Ribble Valley Borough Council
By email

Your ref 3/2026/0222
Our ref DC/26/1129 v2
Date 02-JUN-26

Location: Highcroft Painter Wood Whalley Old Road Billington BB7 9JD
Proposal: Approval of details reserved by condition 2 (specifications of external materials and surface water drainage scheme) of planning permission 3/2024/1022 granted on appeal.

PROPOSED DRAINAGE PLAN

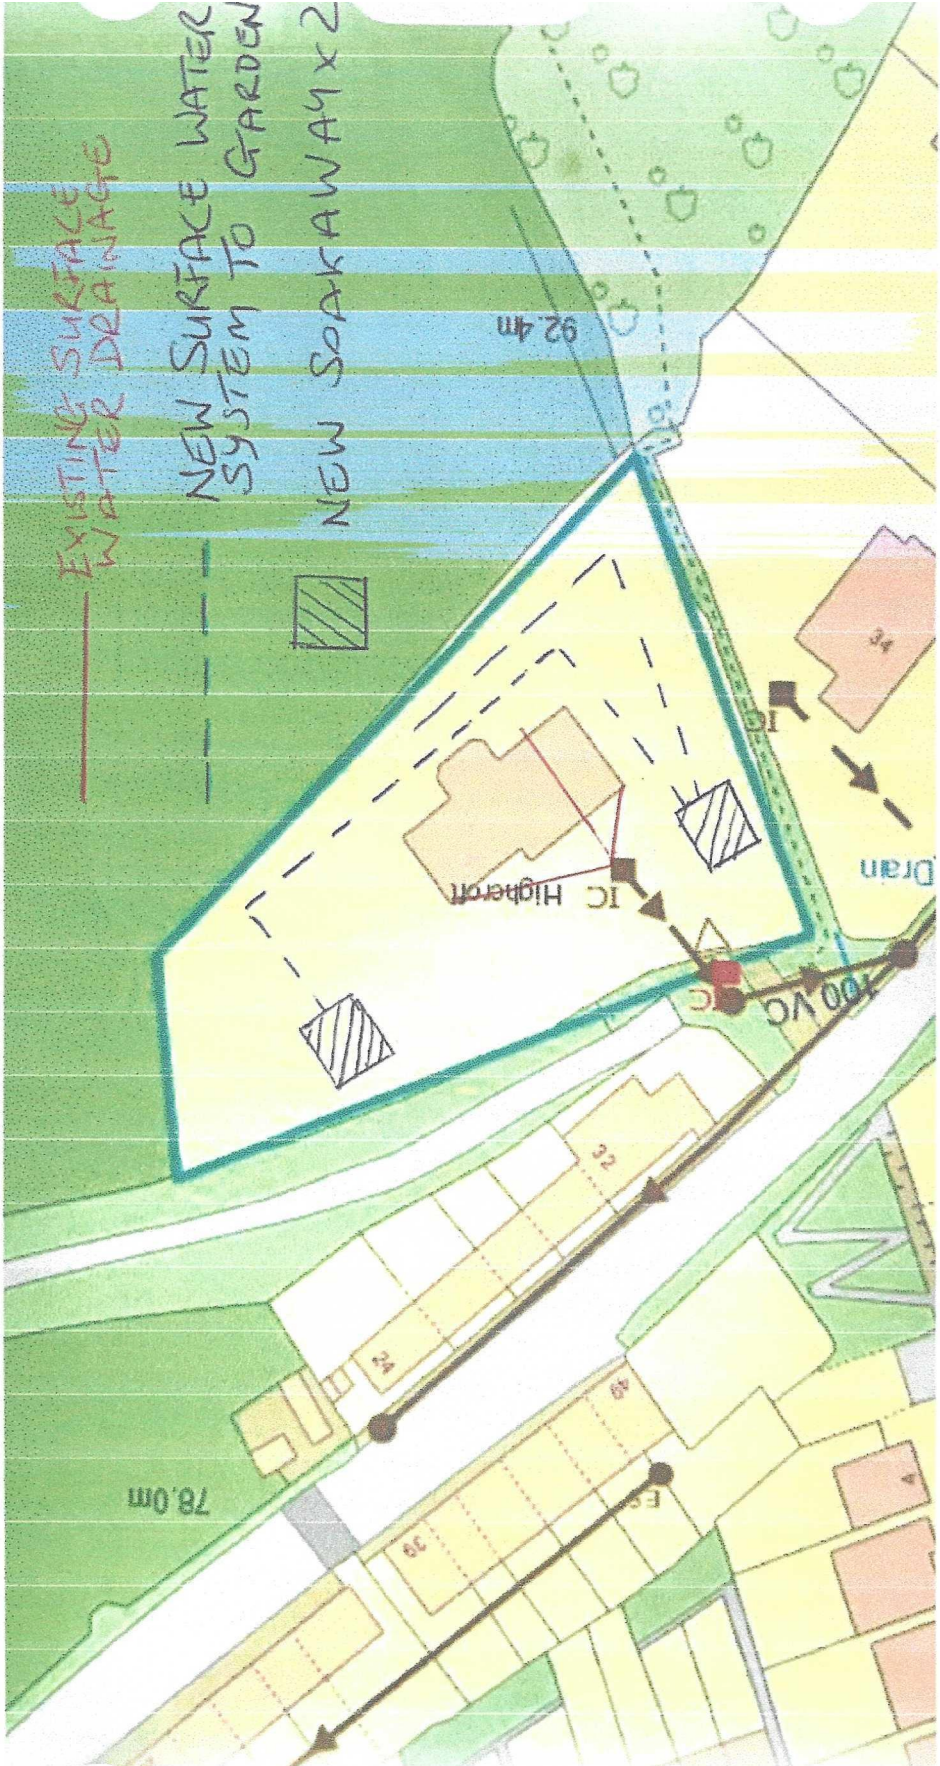
Further to our review of the submitted documents, Proposed Drainage Plan, United Utilities has no objection to condition 2 being discharged as existing drainage arrangement remains the same and ground water to be dealt with within the development and no interaction with sewerage system.
